DECISION DELEGATED TO DEVELOPMENT MANAGER

Application No: H14-0811-20 **Applicant:** Schofield Homes (Spalding) Ltd.

Proposal: Erection of 2 detached dwellings - approved under H14-0440-13. Amendments to driveway surface.

Location: 80 Milestone Lane Pinchbeck Spalding

**DRAWING** BLOCK AND LOCATION PLANS

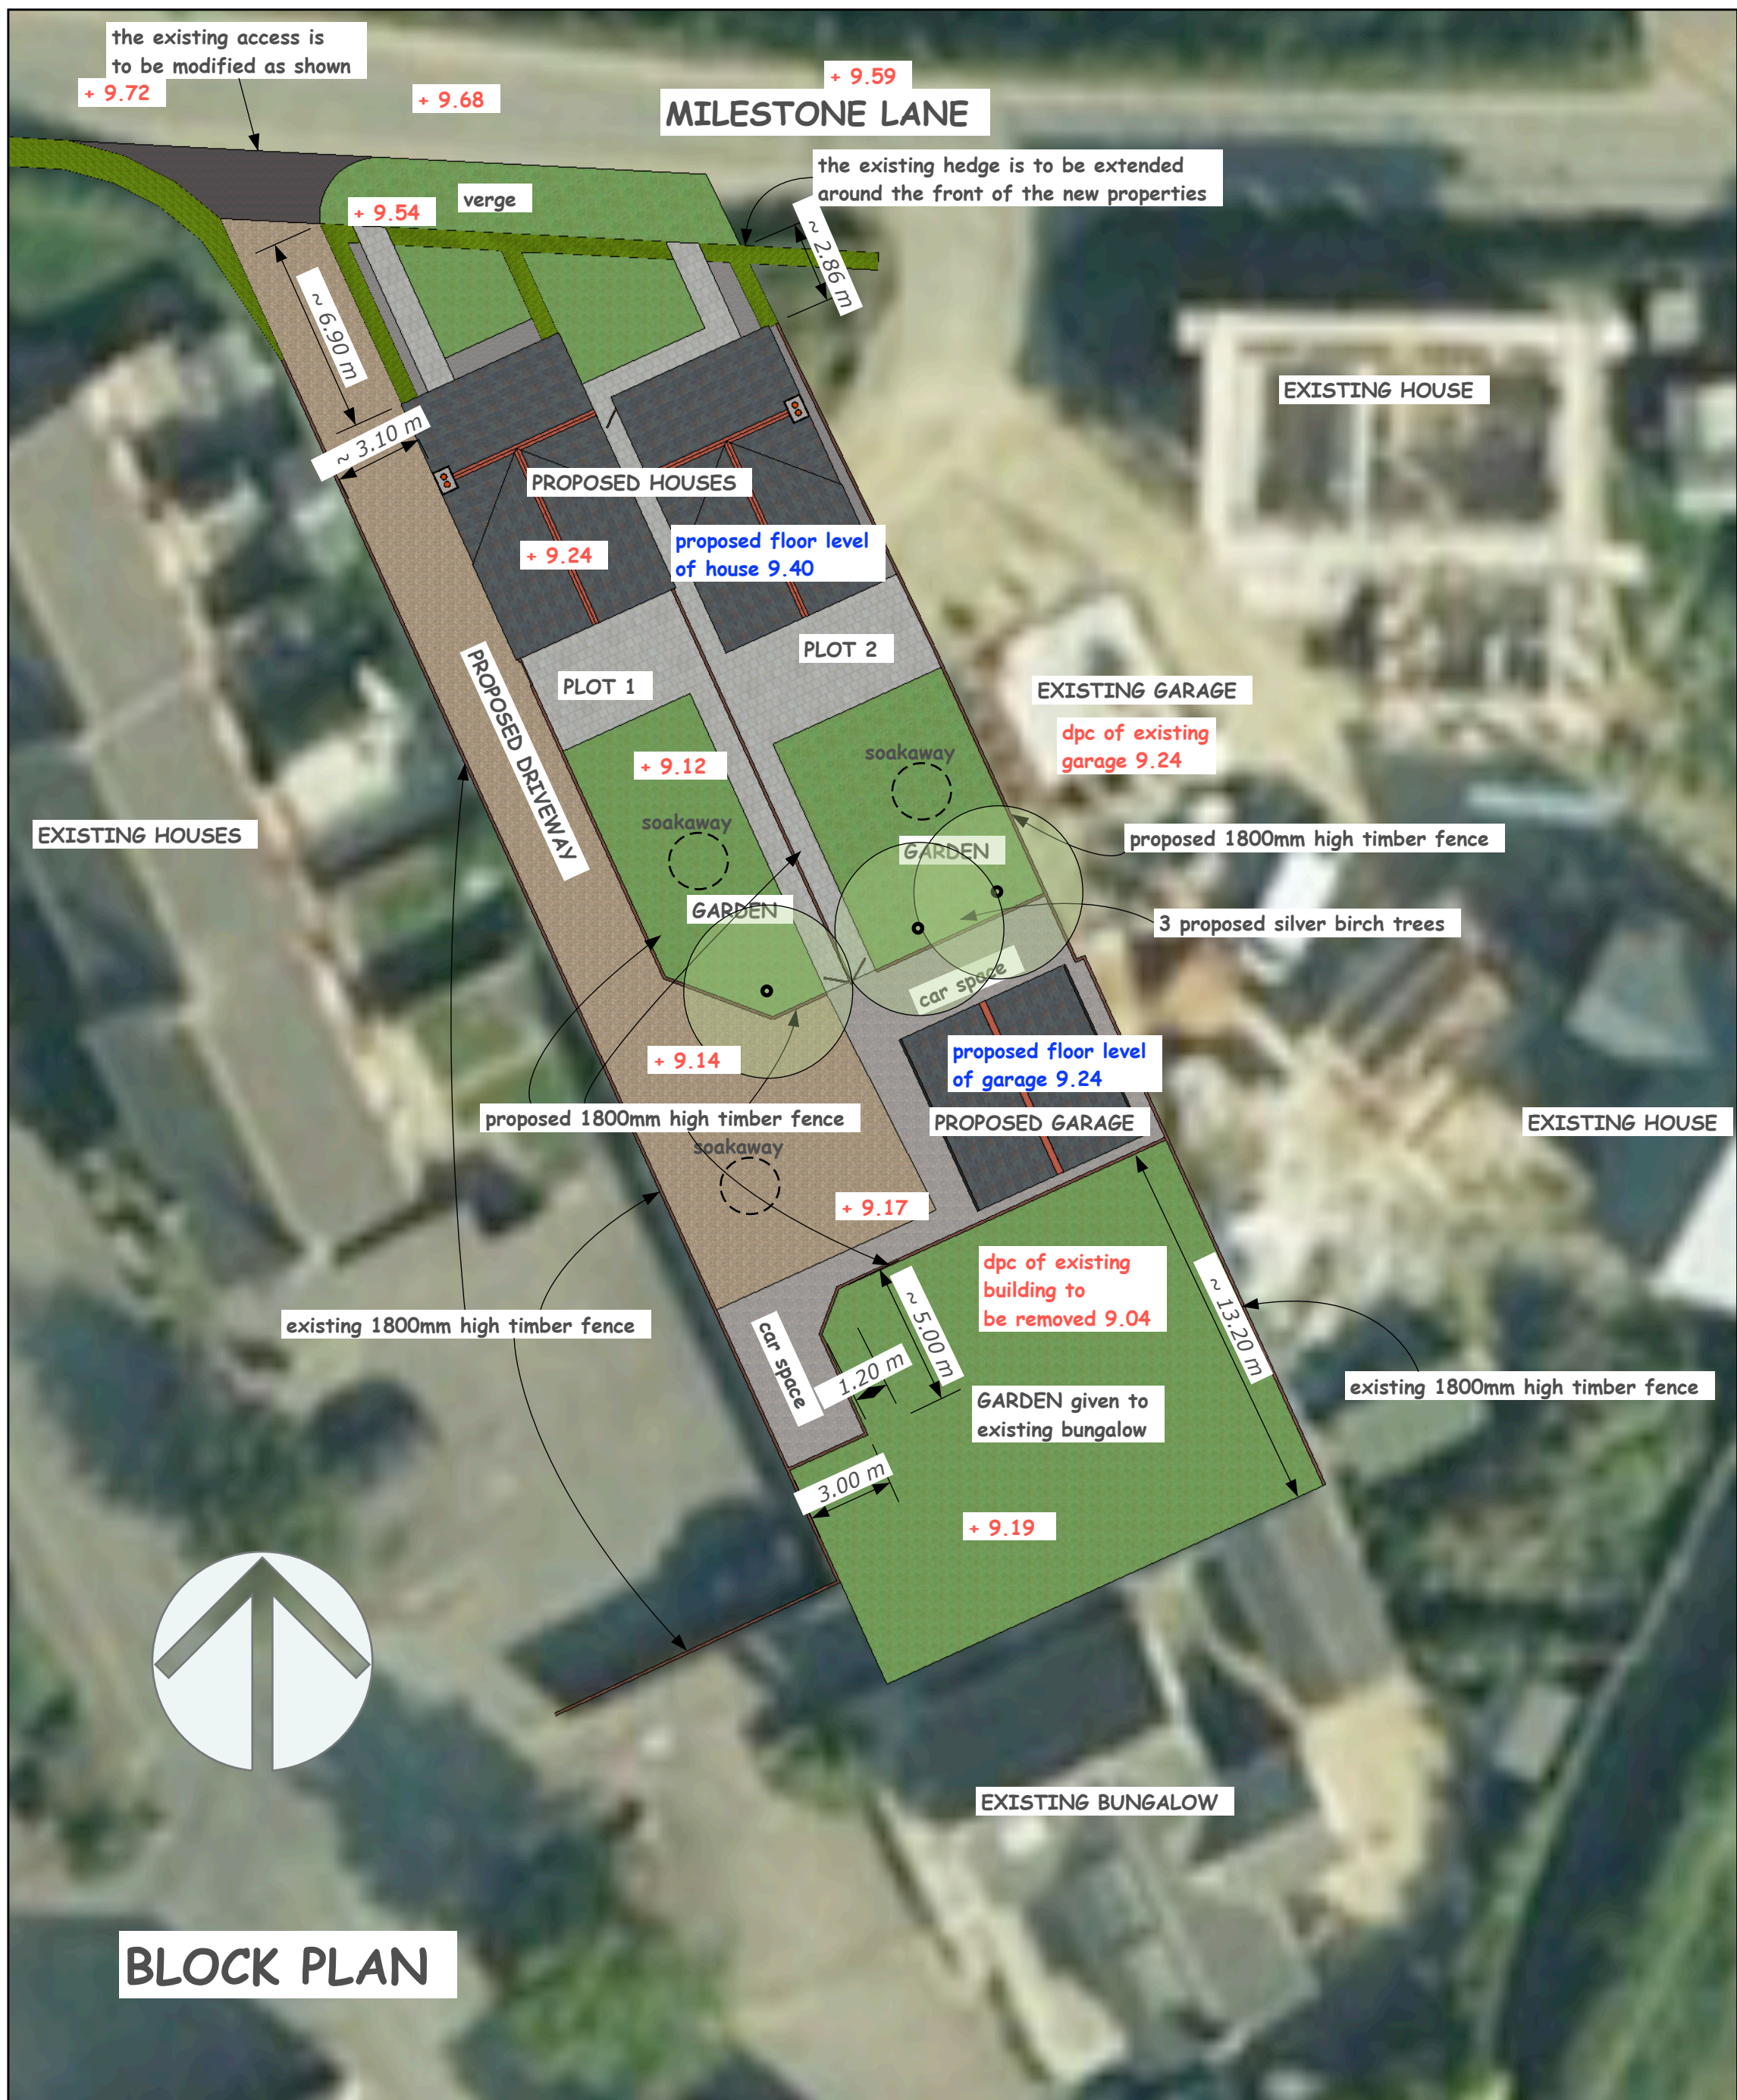
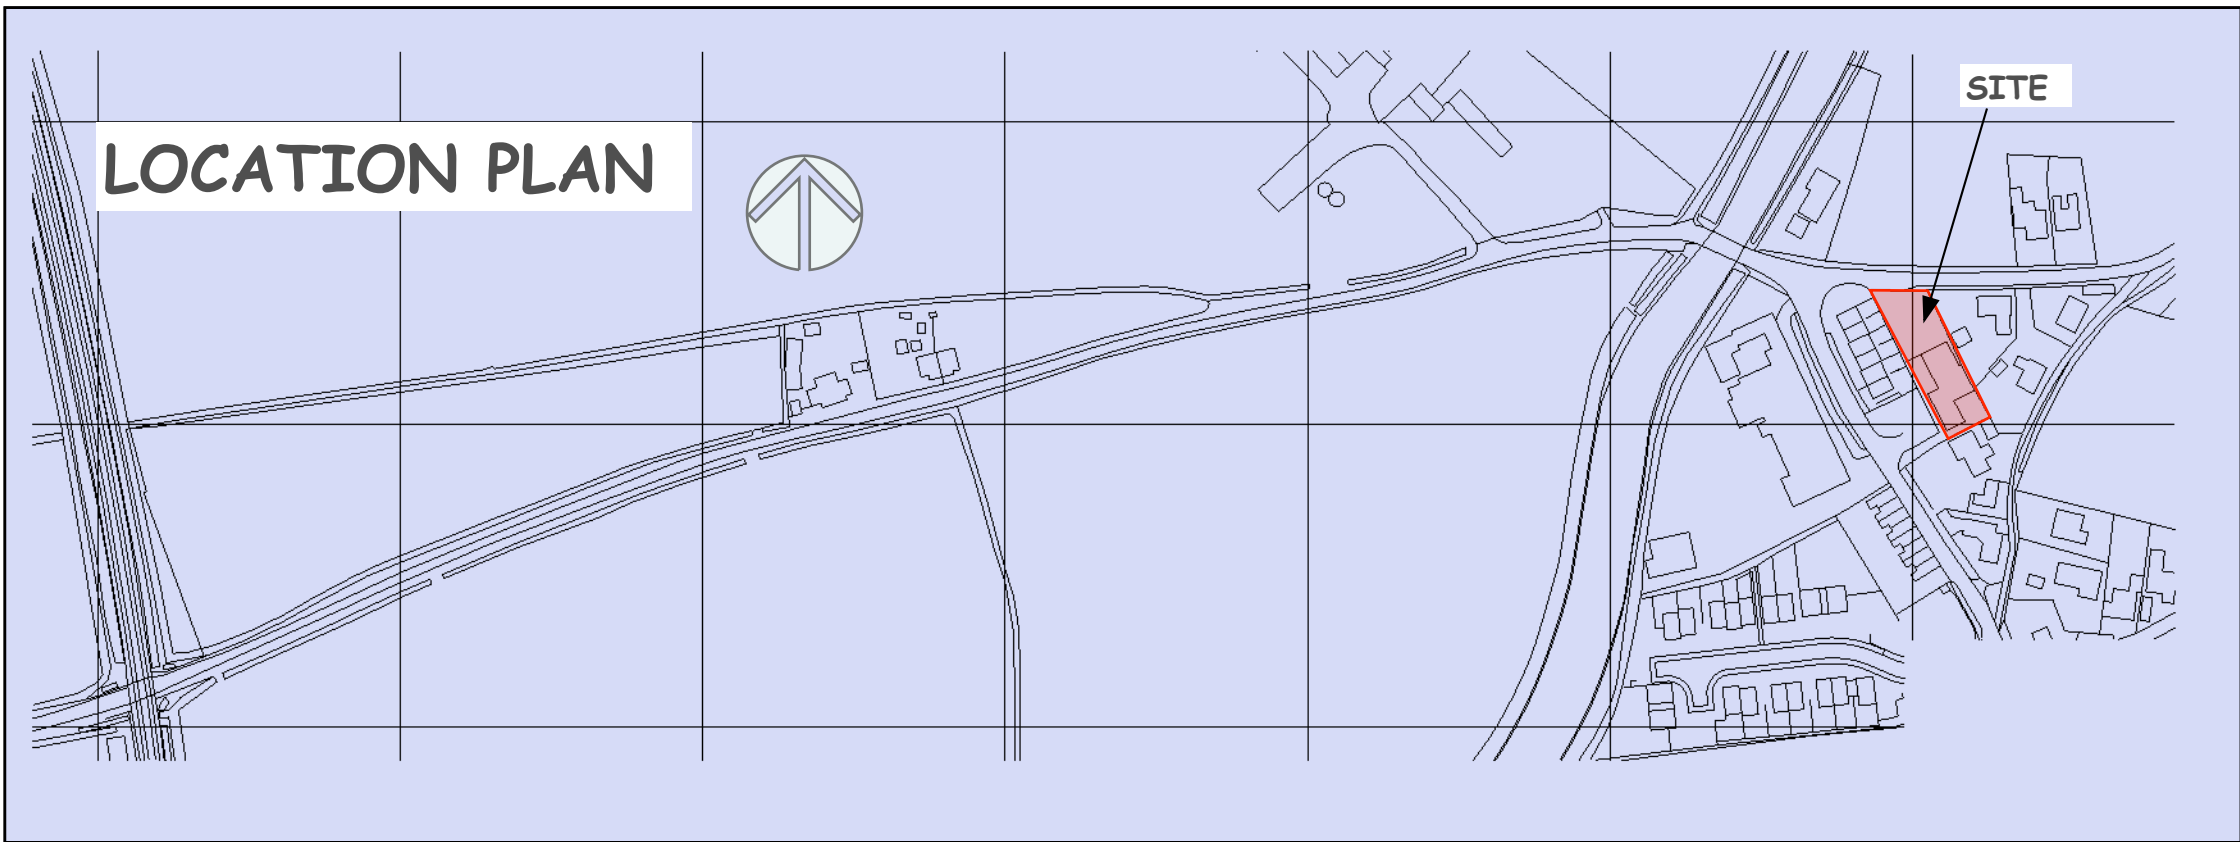
The description of the proposed amendment on the application form reads as follows: "Proposed change of driveway surface. With the garage block not being built the area shaded in black is to be laid to a tarmac surface for easy access to the properties (via garden paths) from vehicles in the parking area. The area shaded in red would like to be changed to a gravel surface, as firstly it is a large surface to tarmac which would cause significant problems with drainage. Therefore gravelling the area would alleviate this problem, but still giving good access from the tarmacked area"

The proposal is considered to constitute a non-material amendment as the proposed tarmac area is to the rear of the property. The proposed tarmac area is assessed against Class F, Part 1 of the General Permitted Development Order (2015) titled.

"(a) the hard surface would be situated on land between a wall forming the principal elevation of the dwellinghouse and a highway, and
(b) the area of ground covered by the hard surface, or the area of hard surface replaced, would exceed 5 square metres,
either the hard surface is made of porous materials, or provision is made to direct run-off water from the hard surface to a permeable or porous area or surface within the curtilage of the dwellinghouse."

The proposed tarmac area is to the rear of the property, therefore, an application for full planning permission is not required.

There is not considered to be a material impact from the proposal as the area is surrounded by boundary treatment and surface water can still be drained by the nearby gravel provision to the front, side and rear of the property.

The proposed tarmac area constitutes a non-material amendment not requiring full planning permission.

This application is recommended for approval.
